EPC STORMWATER REVIEW COMMENTS
 IN ORANGE BOXES WITH BLACK TEXT

EL PASO COUNTY GRADING AND EROSION CONTROL PLAN CHECKLIST

EPC Project Number: 241

Table with 6 columns: SLOPE, SPACING @ 1.5 CD HEIGHT, and values for 2%, 3%, 4%, 5%, 6%, 7% slopes.

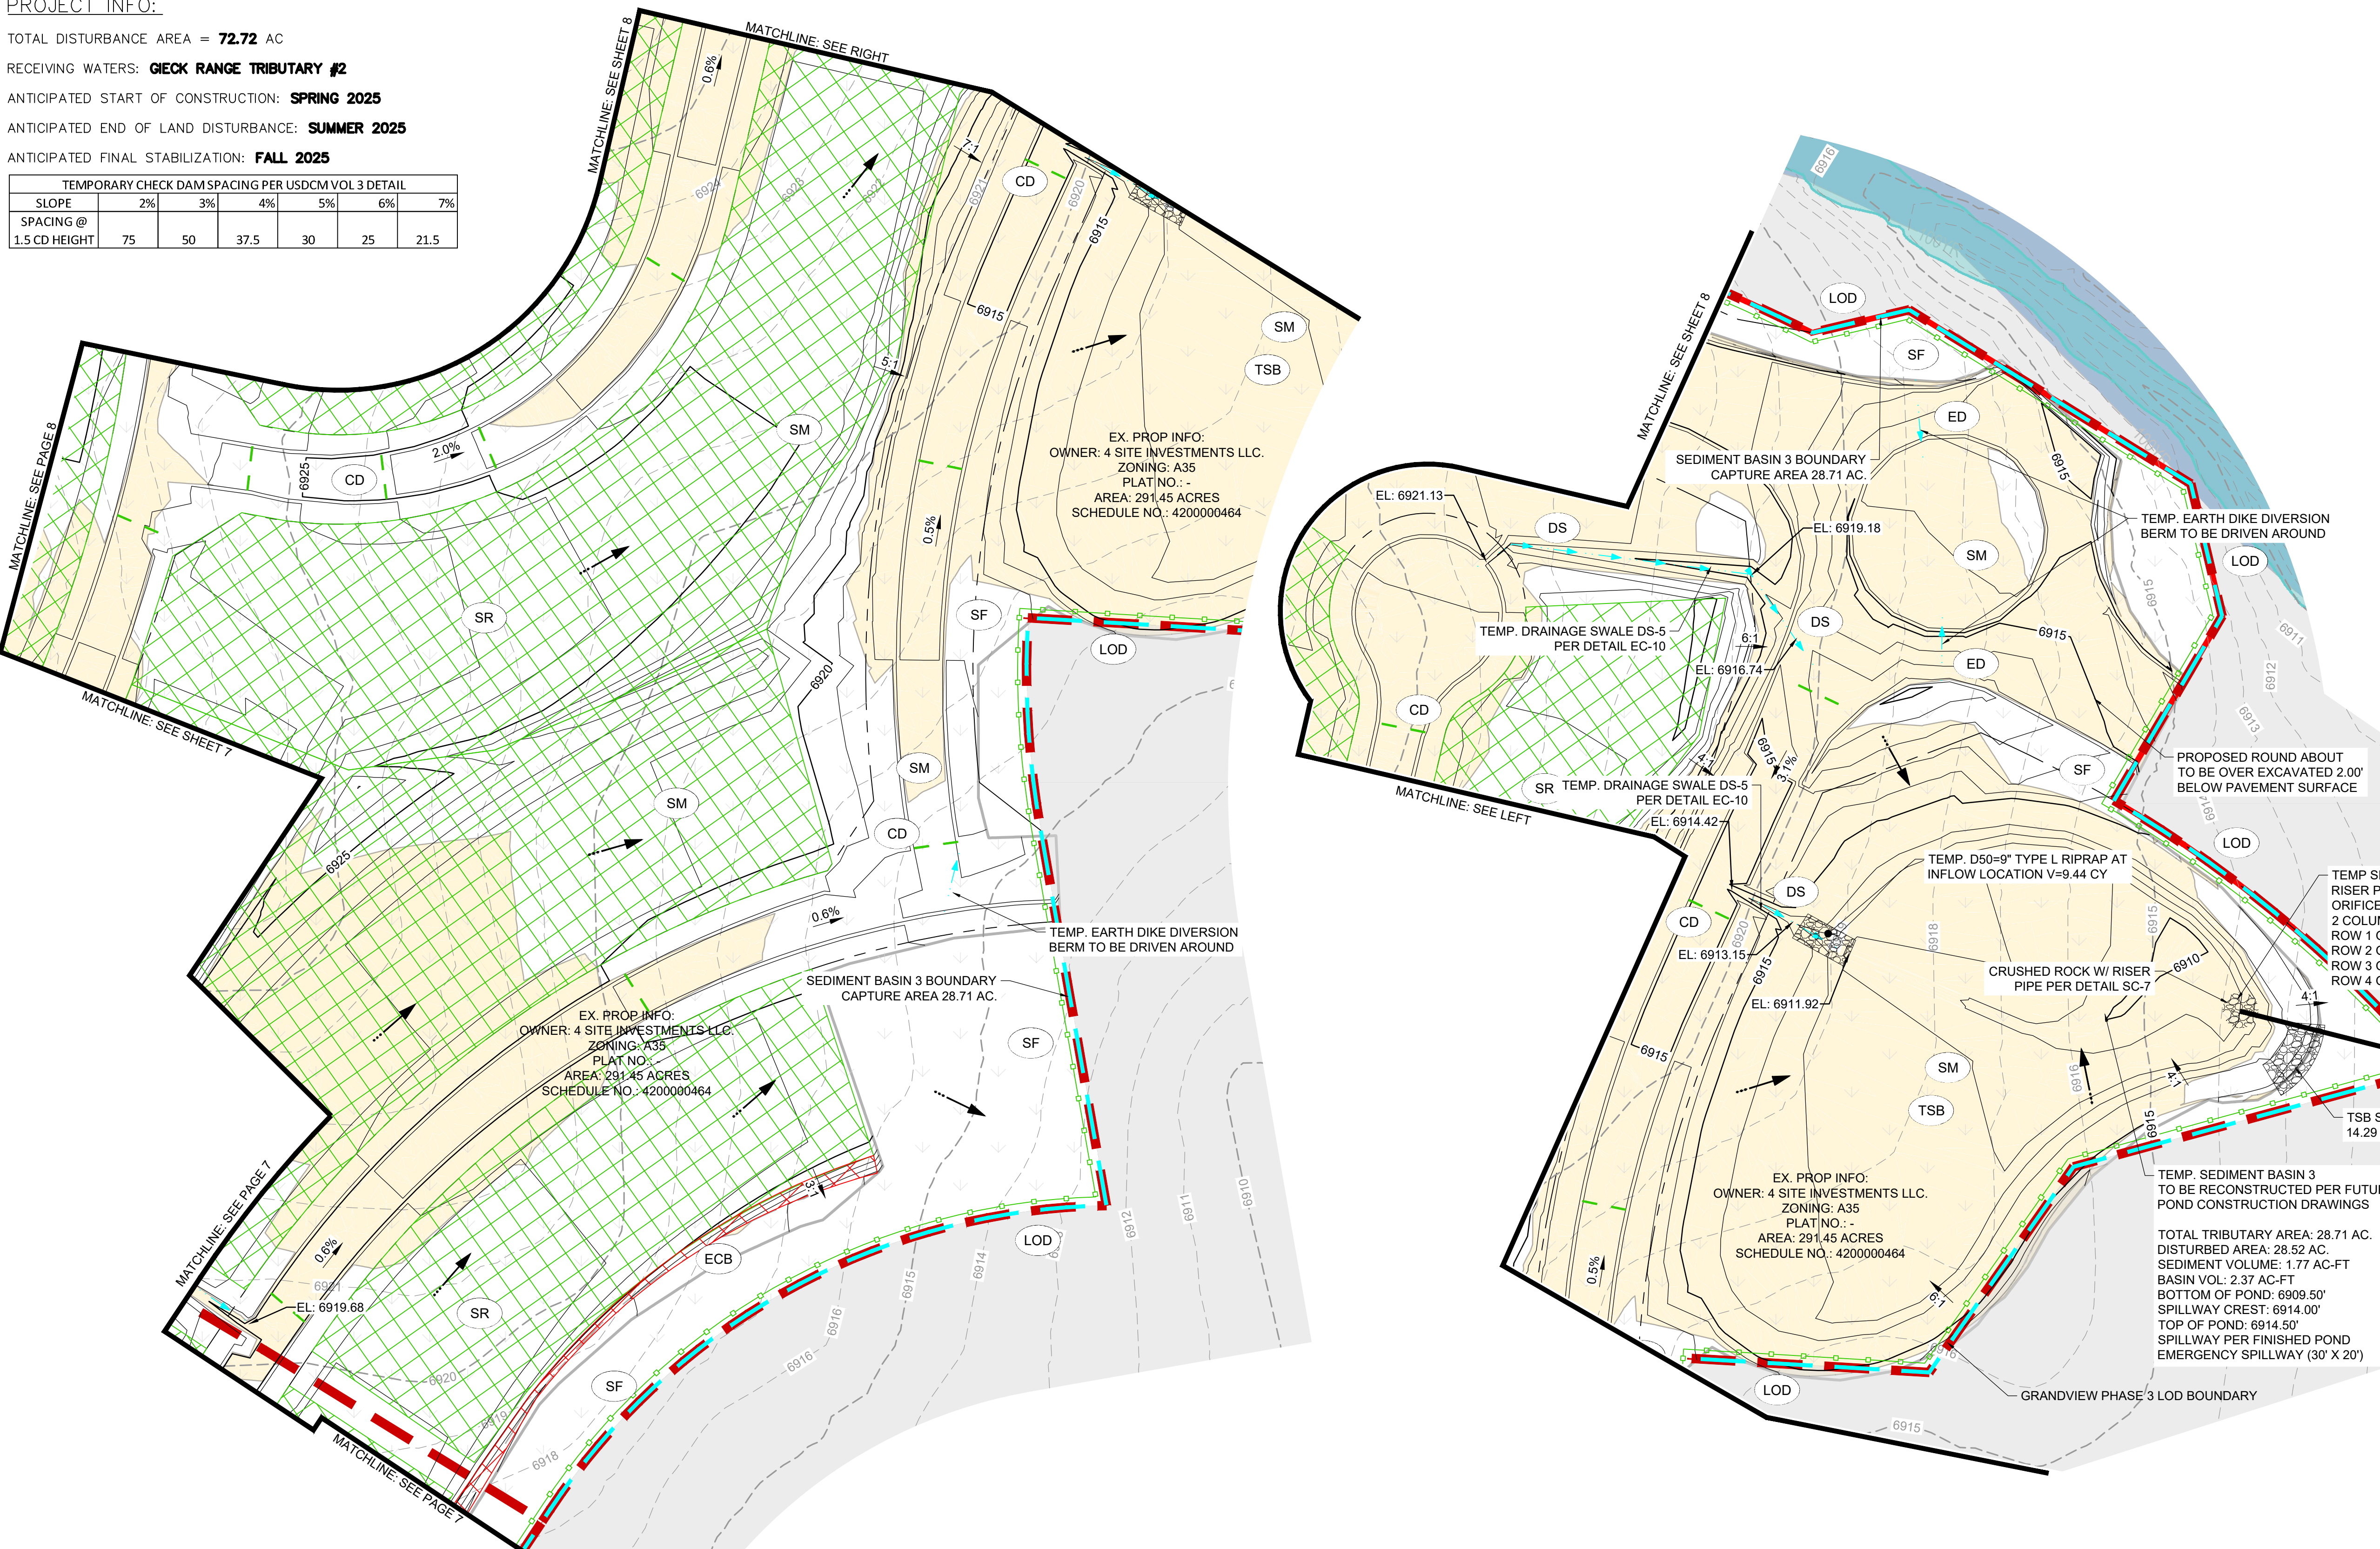
v	All proposed temporary construction control measures, structural and non-structural. Temporary construction control measures shall be identified by phase of implementation to include "initial," "interim," and "final" or shown on separate phased maps identifying each phase		N
w	Vehicle tracking provided at all construction entrances/exits. Construction fencing, barricades, and/or signage provided at access points not to be used for construction		Y
x	Temporary sediment ponds provided for disturbed drainage areas greater than 1 acre		Y
